CITY OF ALBUQUERQUE

August 15, 2005

Re: HARRISON BUILDING ADDITION
1420 Mission Avenue NE
Approval of Temporary Certificate of Occupancy (C.O.)
APPROVED Engineer's Stamp dated 03/04/2005 (F-16/D20A)
SUBMITTED Engineer's Stamp dated 10/17/2001
Certification dated 08/15/2005

ENGINEER'S SEAL	TRACT 3A-3-A-3 RENAISSANCE CENTER	DRAWN BY WCWJ
	AMENDED GRADING AND DRAINAGE PLAN	DATE 10-10-01
	TIERRA WEST, LLC 8509 JEFFERSON NE ALBUQUERQUE, NEW MEXICO 87113 (505)858-3100	SHEET # 2 OF 12
RONALD R. BOHANNAN P.E. #17668		JOB # 990078

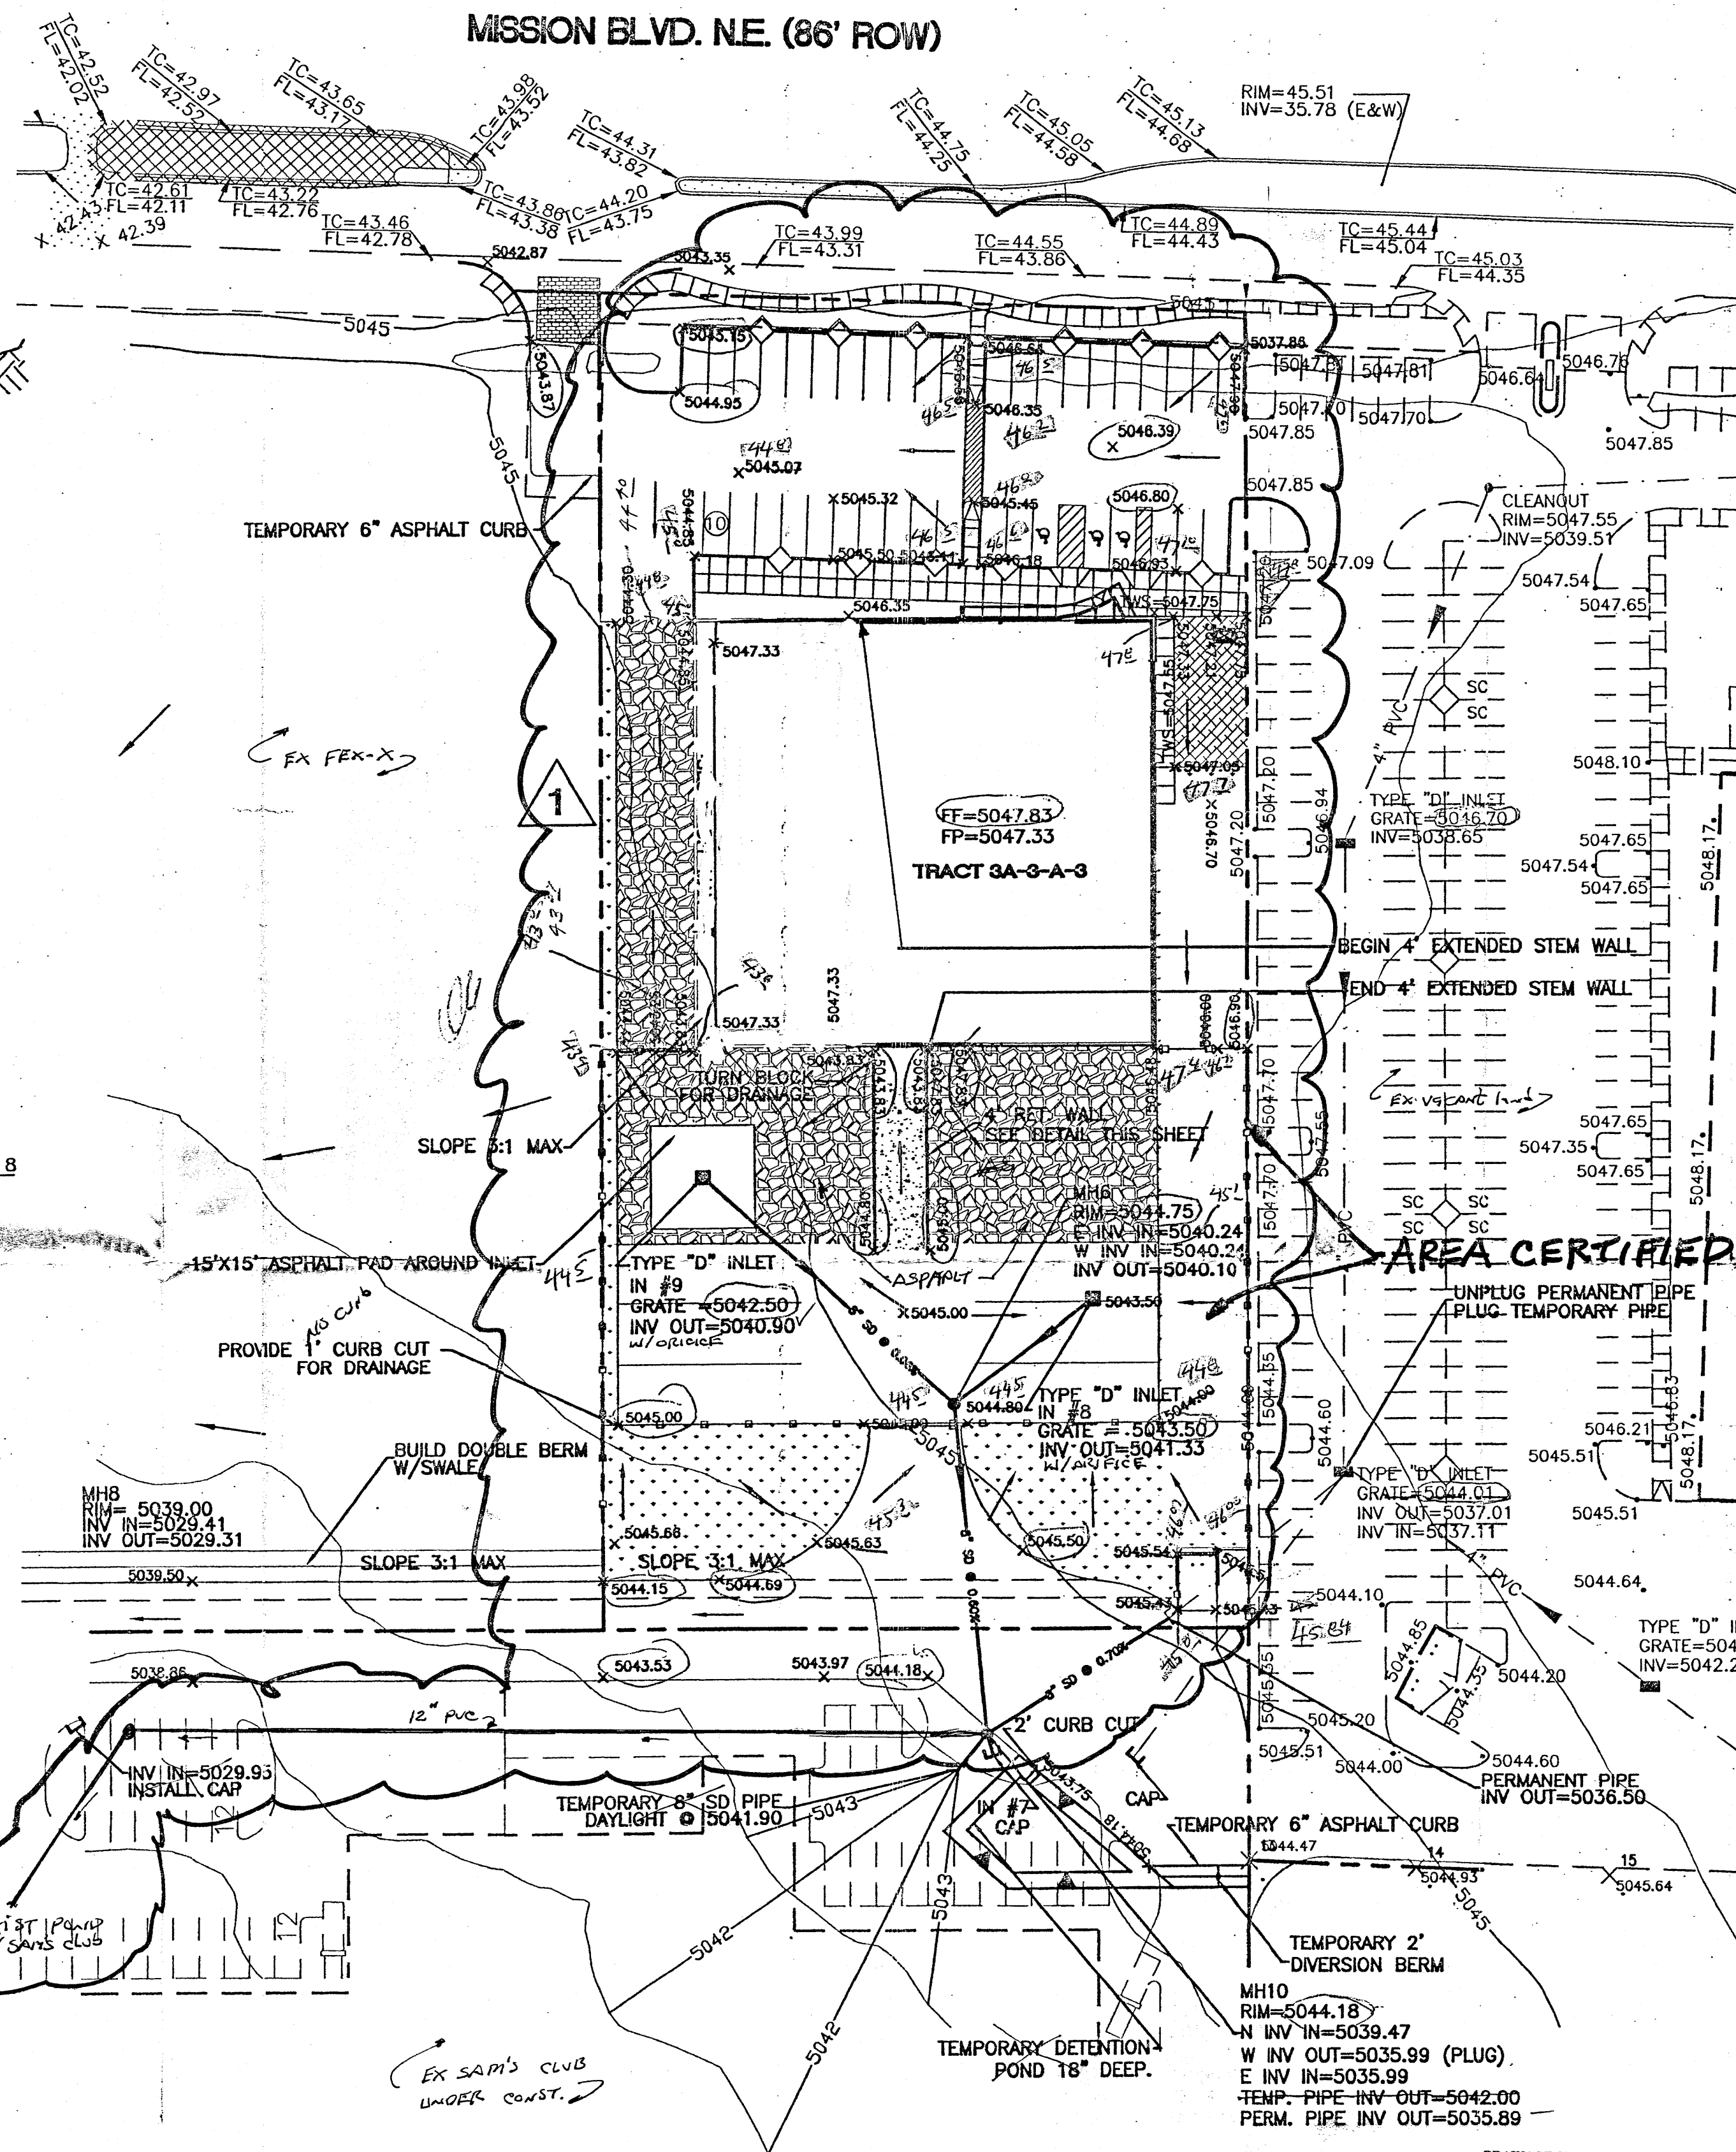
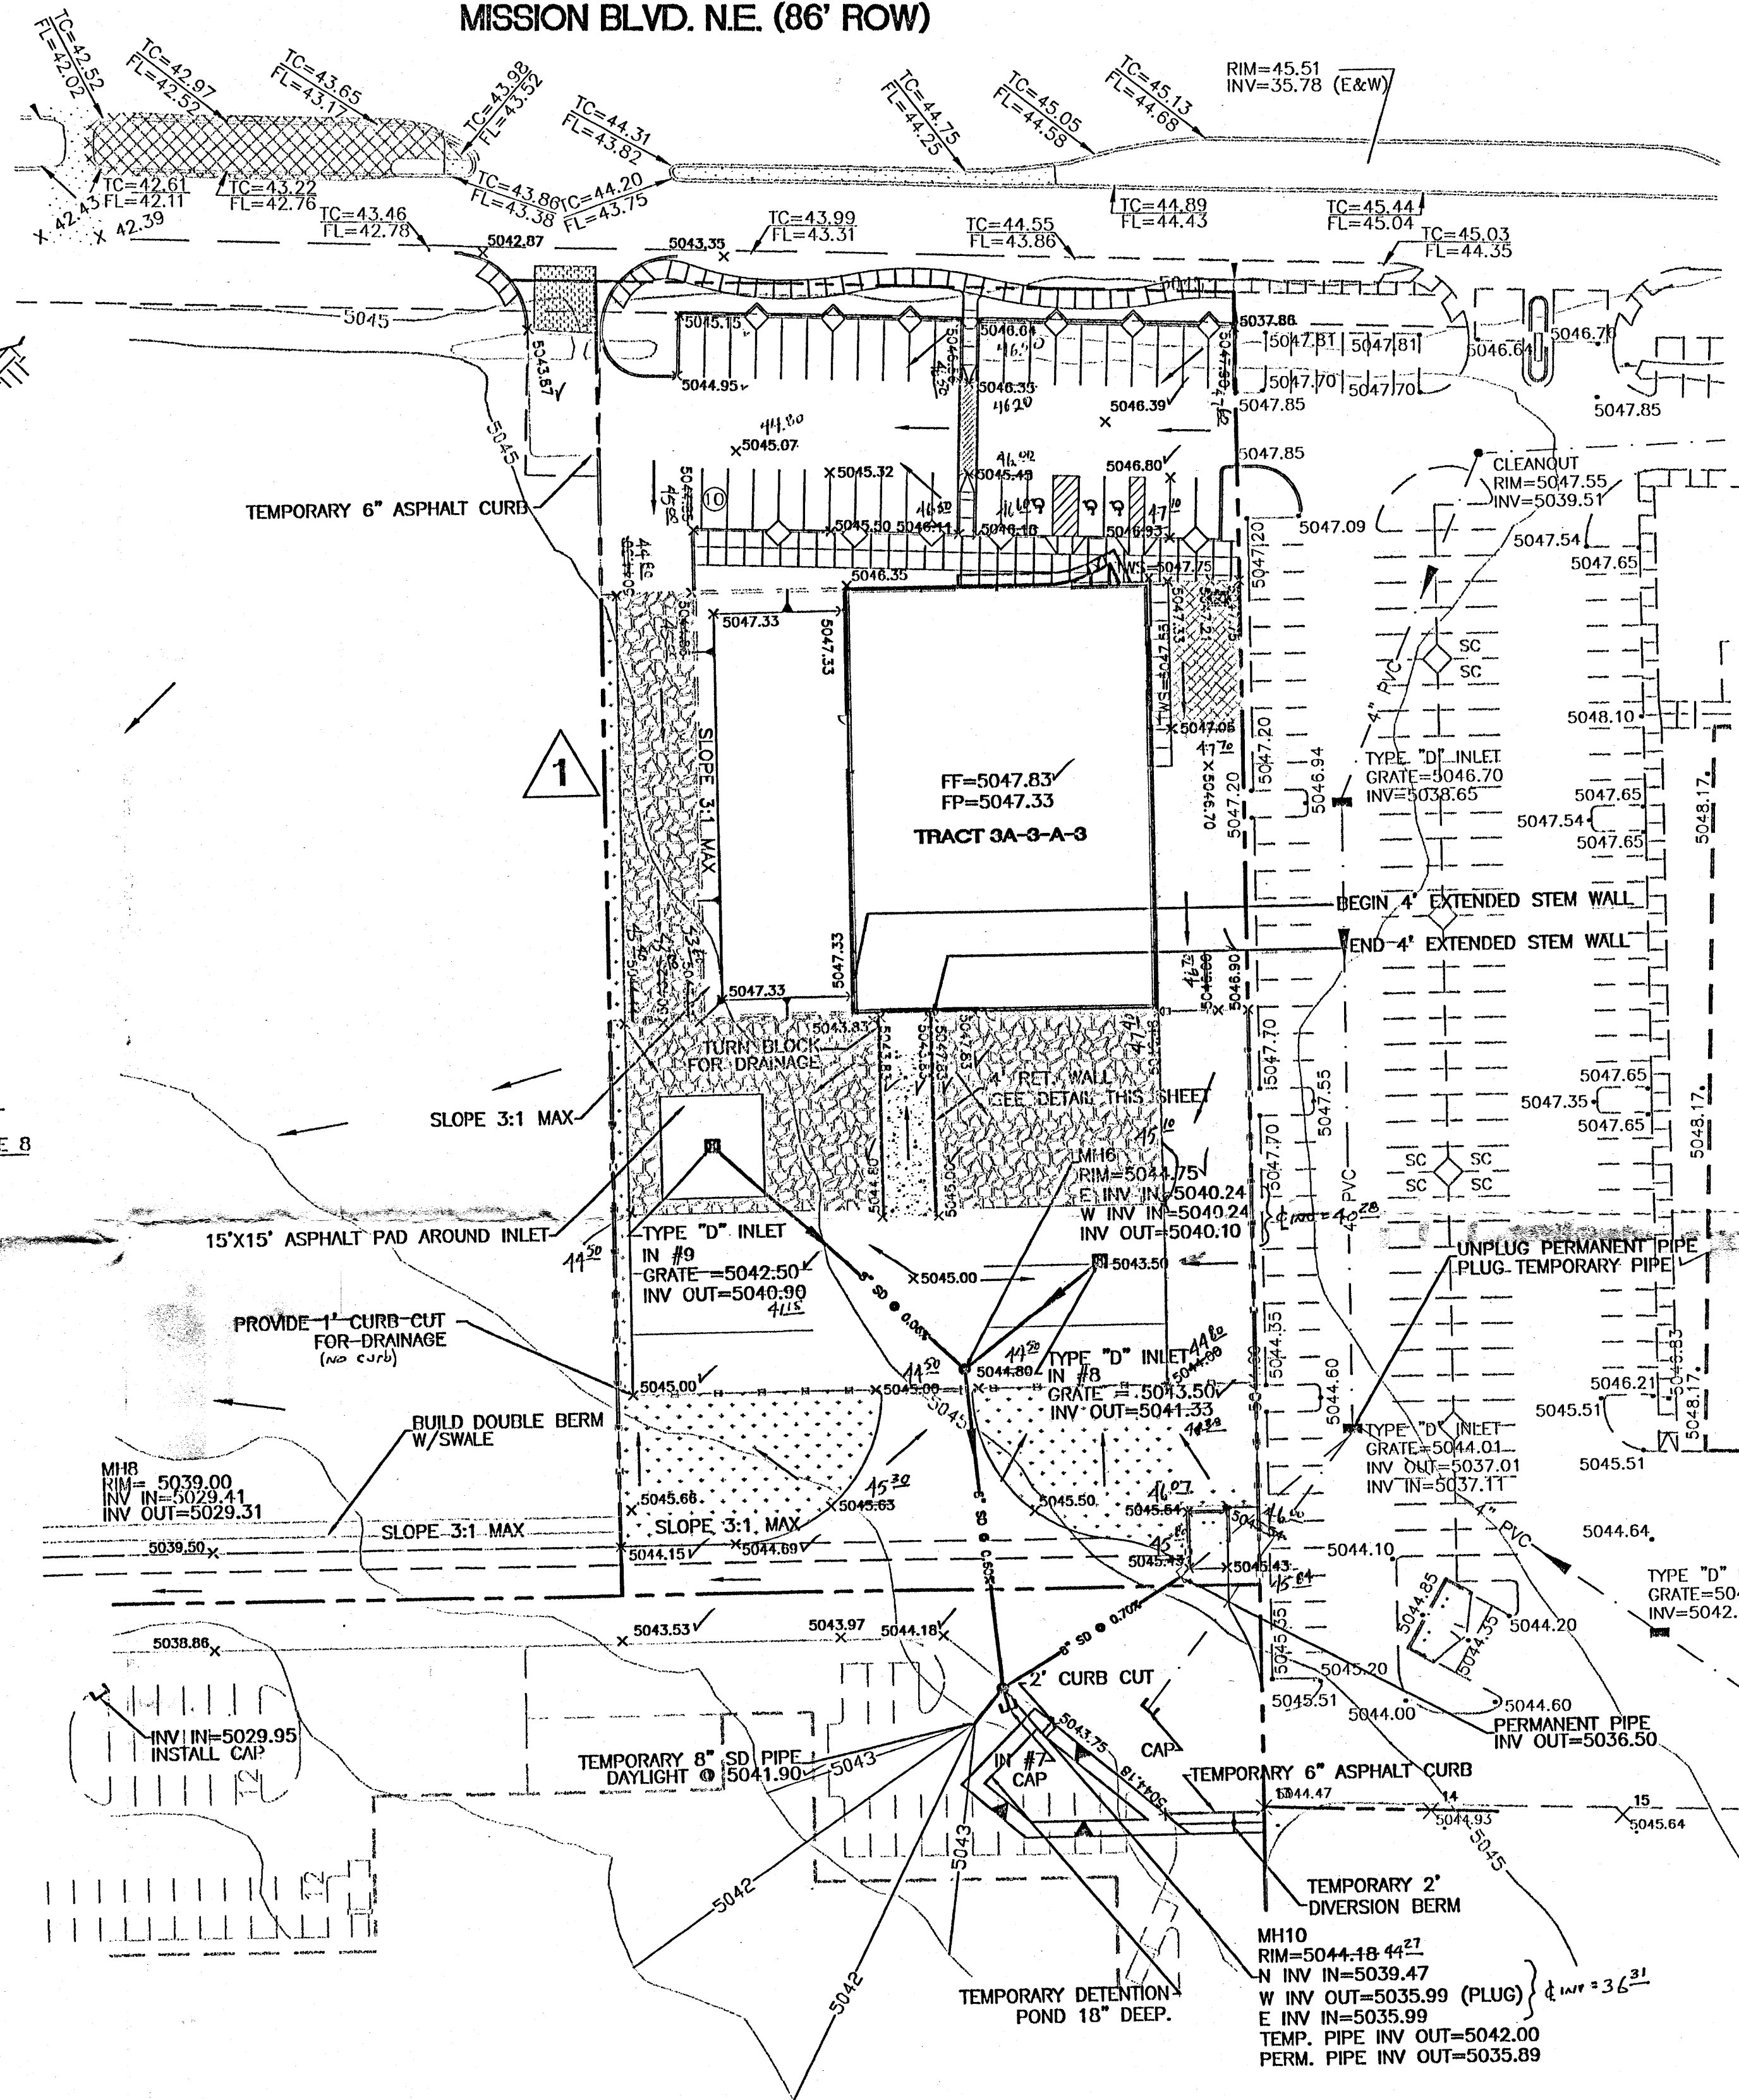
Please Note: The Grading/Drainage Plan (G/D), submitted was not the Approved Plan. The Certification and as-built elevations should be made on a copy of the Approved Grading and Drainage Plan with the Engineer Stamp date of 03/04/2005. When submitting for Permanent C.O., please place Certification/As-built elevations on a copy of the Approved G/D plan. Thanks.
